Recommendation: Refuse

Proposal: The garage to be located as the previously granted planning permission 17/00923/F and to be rendered instead of timber clad. The proposed extension layout to be altered to utilise the existing built extensions. The Outbuilding to be removed from the application. Windows in the existing house to be retained. Existing site access to be retained. (Proposed as non-material amendments to 19/01338/F)

DATE: 30 March 2021

project Faraday House Woodway Road Sibford Ferris Oxfordshire OX15 5RF	drwg no	rev
	224_05_301	P2
	title Proposed East Elevation	
scale 1:100 @ A3

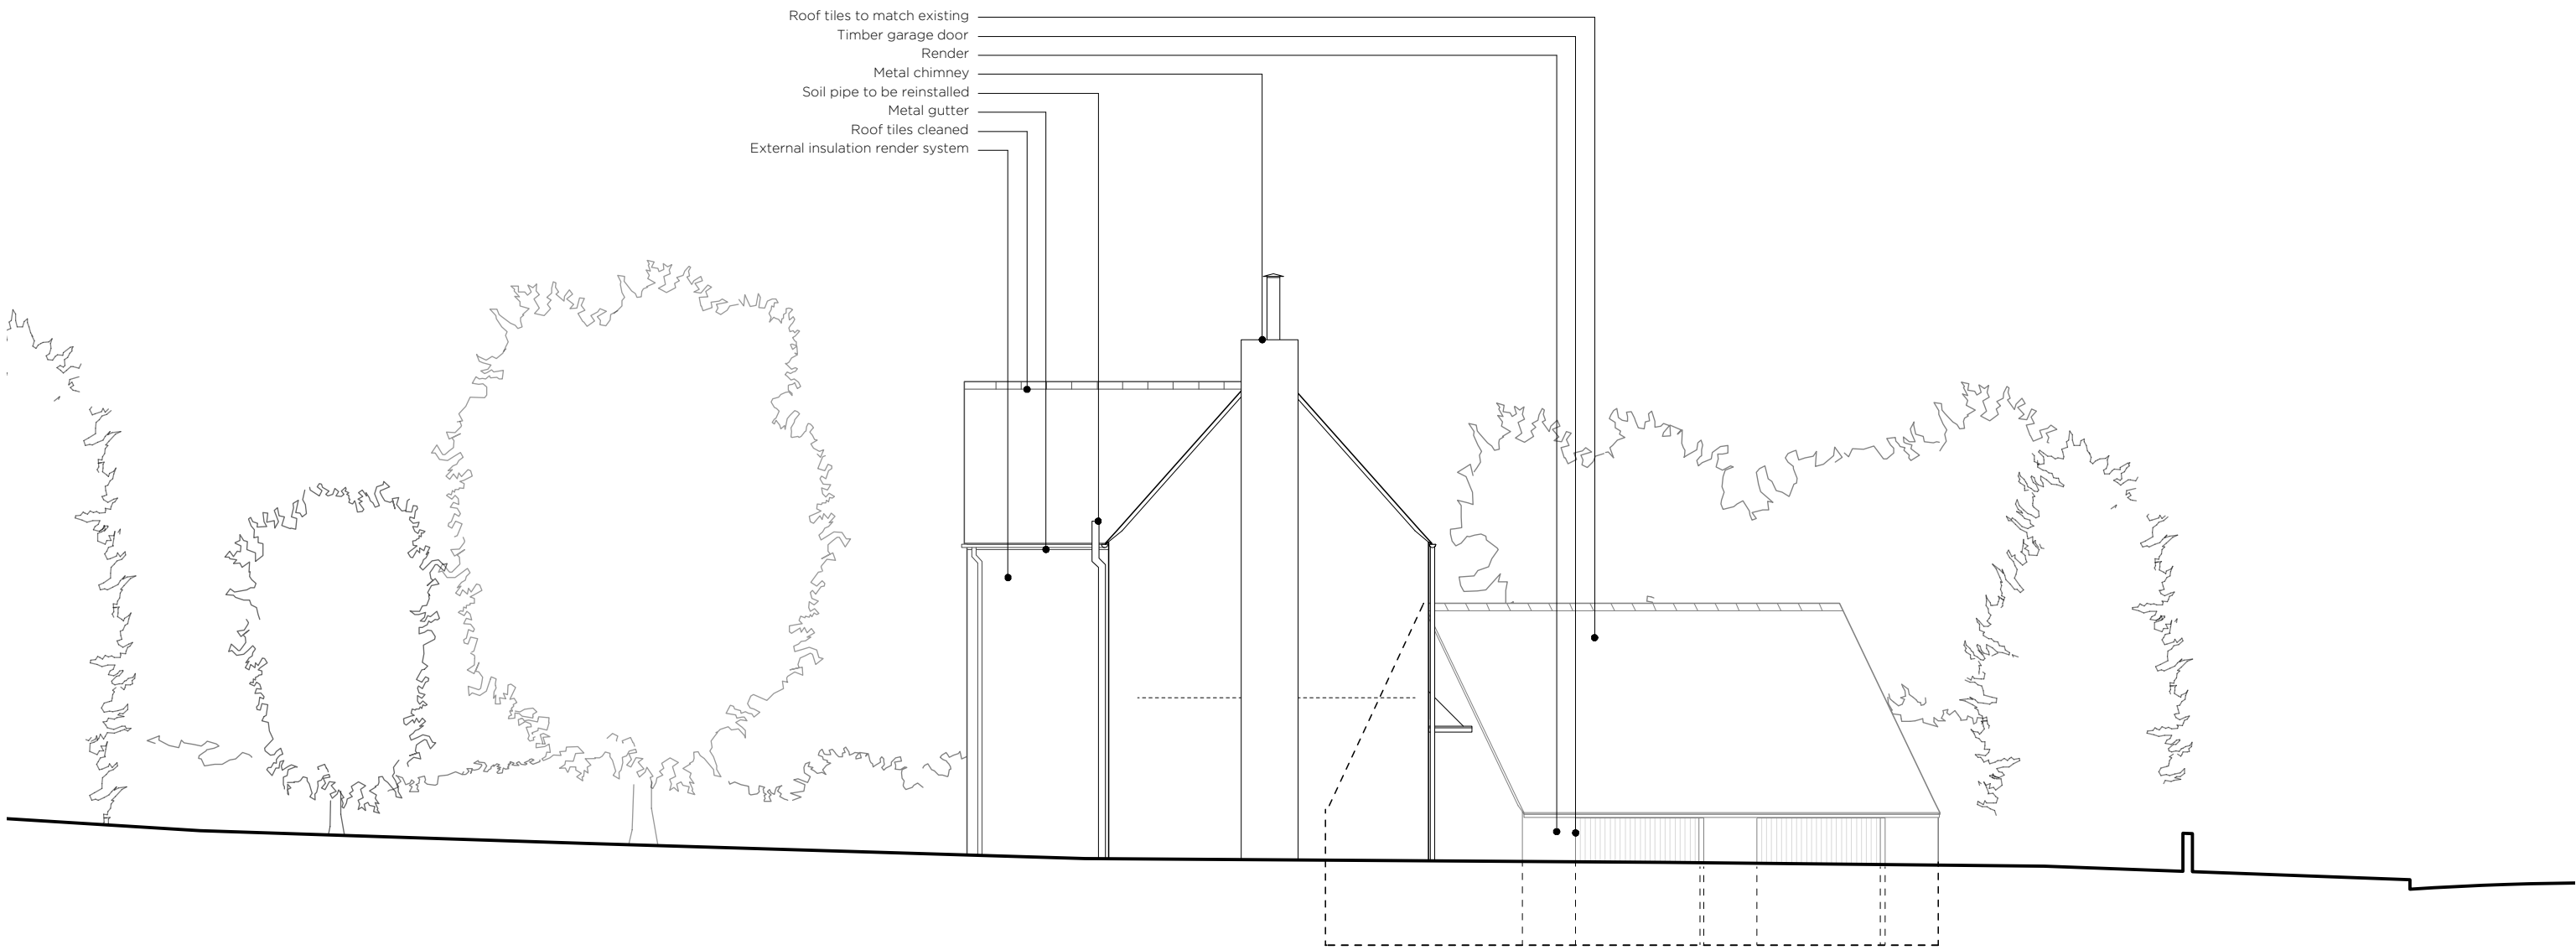
5.5. The area not considered a non-material amendment is the provision of the double detached garage which is materially different to the approved scheme. The desire appears to be to pick and choose parts of the two permissions to create a new permission. This application seeks amendments to the 19/01338/F permission which maintained a garage on the east side of the dwelling whereas the suggested amended seeks a new detached double garage on the west side of the dwelling. The permission 17/00923/F did show an attached double garage in this location but it is not possible under s96A to combine two approved schemes to create a fresh proposal, and it is noted that the earlier consent lapsed in June 2020. This application seeks changes to the later permission which did not show any garage in this location. This significant alteration is therefore not considered to be a non-material amendment to the approved scheme.

6.1. The proposal is considered to be a material change to the approved scheme because provision of the double detached garage which is materially different to the approved scheme under application 19/01338/F. The application is therefore recommended for refusal.
